Re: Hanson Concrete Plant application at Berth 1 and land adjacent, Glebe Island
Application # SSD 8544

OBJECTION

HANSON EIS REVIEW

Hanson Aggregate Facility & Concrete Plant - Glebe Island									
Drawn	AD	Date	05.03.2018	Scale	1:100	Job No	Glebe Island	Drawing Number	Rev A
Checked	AD	By							
Approved	AD	By

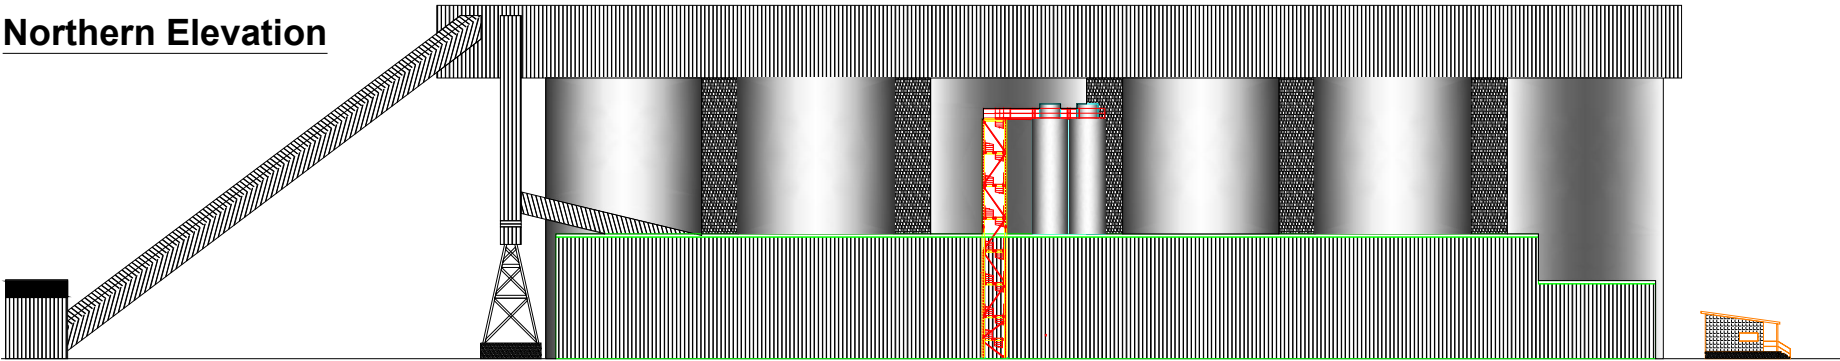
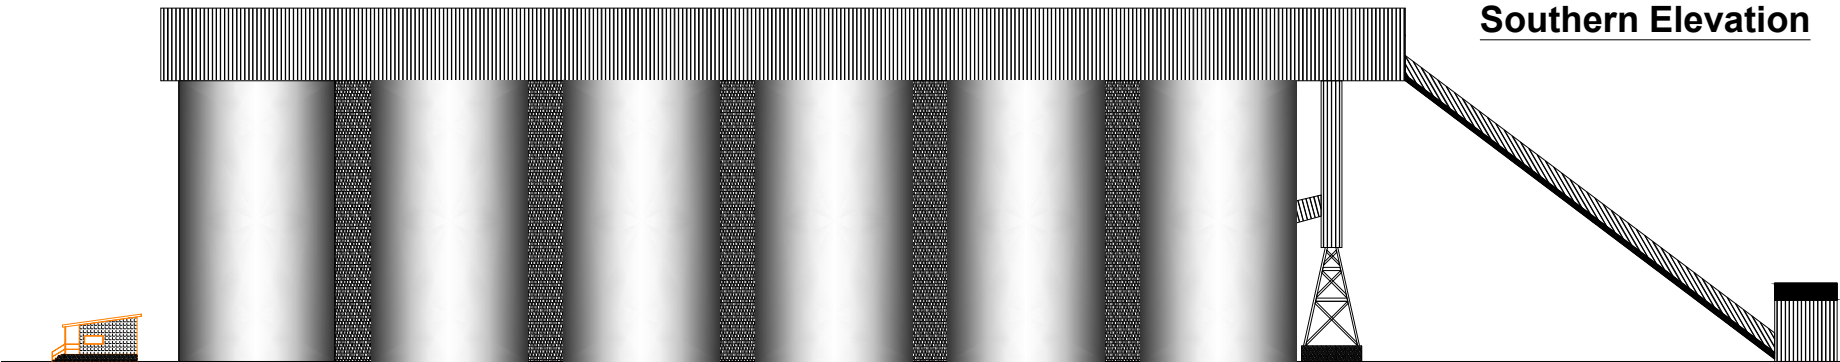
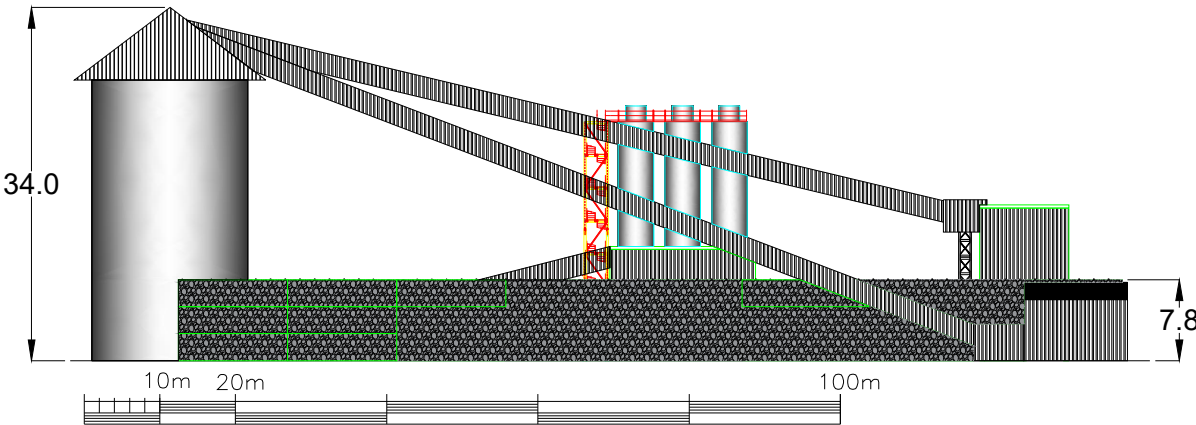
Comment: *These appear to be deceptive statements attempting to convince people that the proposed concrete batching plant is other than it is – very large!*

34-metre high silos do not represent a low-profile design sympathetic to its surrounding environs. 34 metres is the equivalent of an 11-storey building! To put this into perspective, Evolve (the apartment building directly opposite the proposed concrete plant) is 12-storeys in height. I understand that the existing Glebe Island Silos are approximately 43m in height. In fact, the scale of this proposal is so large that views of important heritage and iconic buildings such as the Glebe Island Silos and the Anzac Bridge will be obliterated from many vantage points along the public parks and promenades alongside Johnstons Bay. The character of Glebe Island is low-profile. The character of the proposed facility is not.

Comment: The proposed development occupies a site area of over 16,000sqm (approximately 21/2 football fields). The height of the main roof is unclear from the documentation but appears to be around 15m. There are two banks of silos, one (6 silos) being 25m high located in the centre of the building and the other (larger) row of 6 aggregate storage silos along the southern boundary.

This development would appear to most observers as a large-scale industrial building, completely lacking in aesthetic quality; inappropriately sited on the edge of Johnstons Bay and parked awkwardly alongside an existing heritage item; and the antithesis of good urban design. It would be a visual affront

As mentioned in the above comments on section 2.2, this is a very large building located close to significant existing landmarks and over-scaling the waterfront. The photomontage in Fig 13 clearly demonstrates the excessive scale of

this development, with silo heights which will appear to be substantially higher than the existing heritage-listed silos to the west when viewed from the water and many other positions in the area.
